Planning Officer: Mr S Davis

Planning Application Ref: AL/113/21/OUT

Location: Land at Bayard, Level Mare Lane, Eastergate, PO203RZ

Description of works: Outline application with all matters reserved, apart from access, for up to 69 no. dwellings with access, parking, landscaping & associated works. This application is a Departure from the Development Plan

Drawing No	Revision
LLD2327-ARB-DWG-001	01

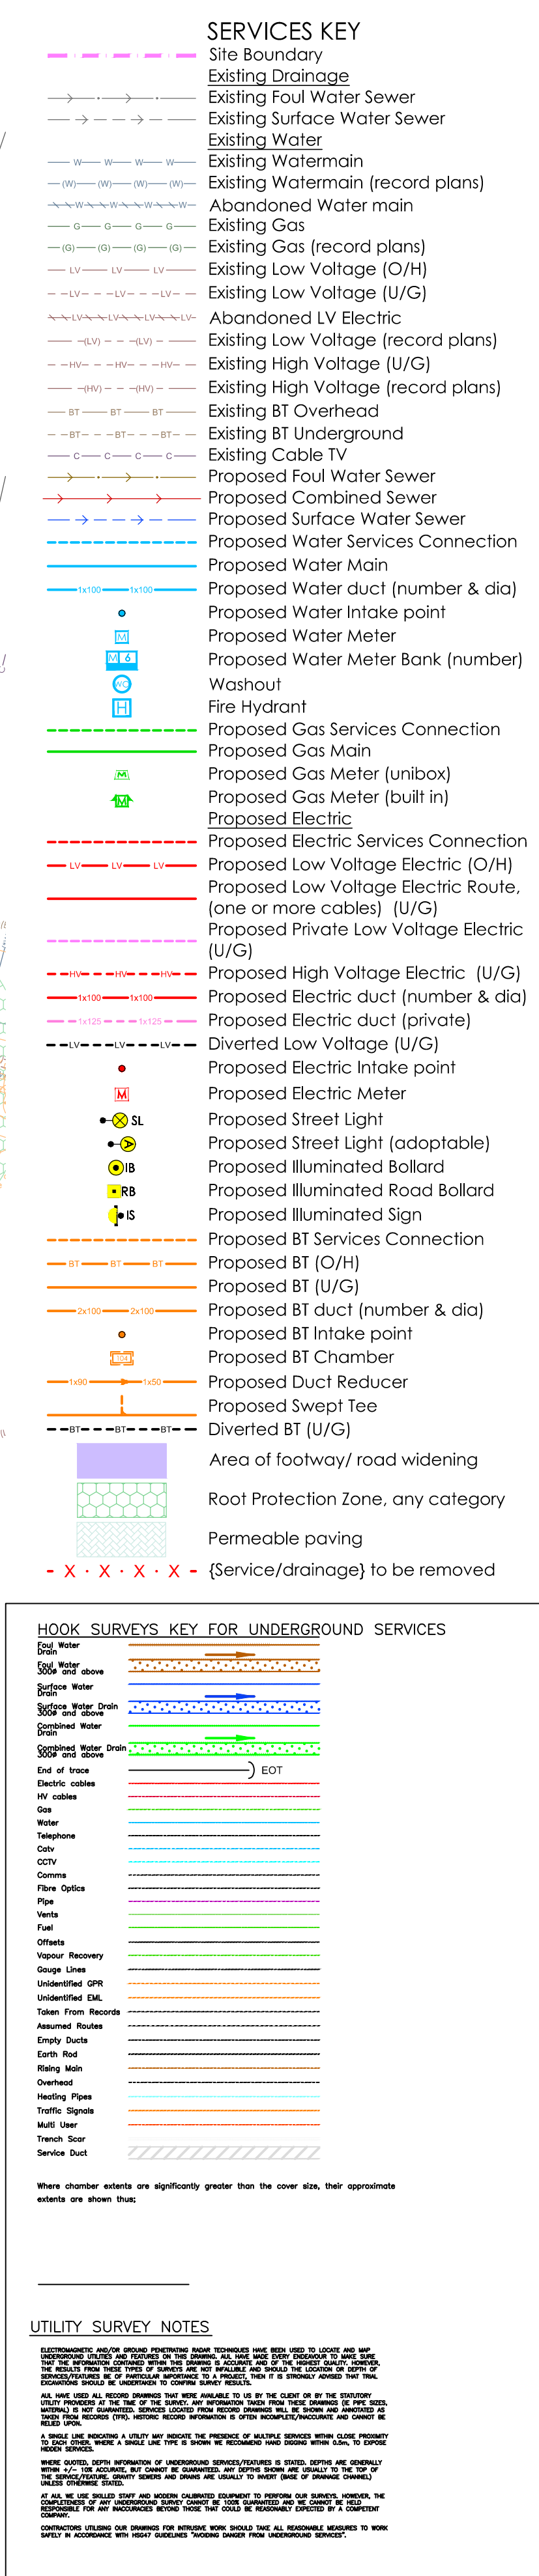
- Given the relatively high level of intrusion into nominal Root Protection Areas (RPAs) shown on the TPP; this is an important early opportunity to consider evolution of layout proposals in advance of any Reserved Matters application. I hope the following comments will inform that process:

- SPD advice on trees and development promotes the use of 2metre buffer zones in addition to nominal RPA (to form an effective Construction Exclusion Zone), such as appears to have been applied to T04 on the TPP. This should be replicated across the site wherever achievable and essentially for all trees subject of TPO.
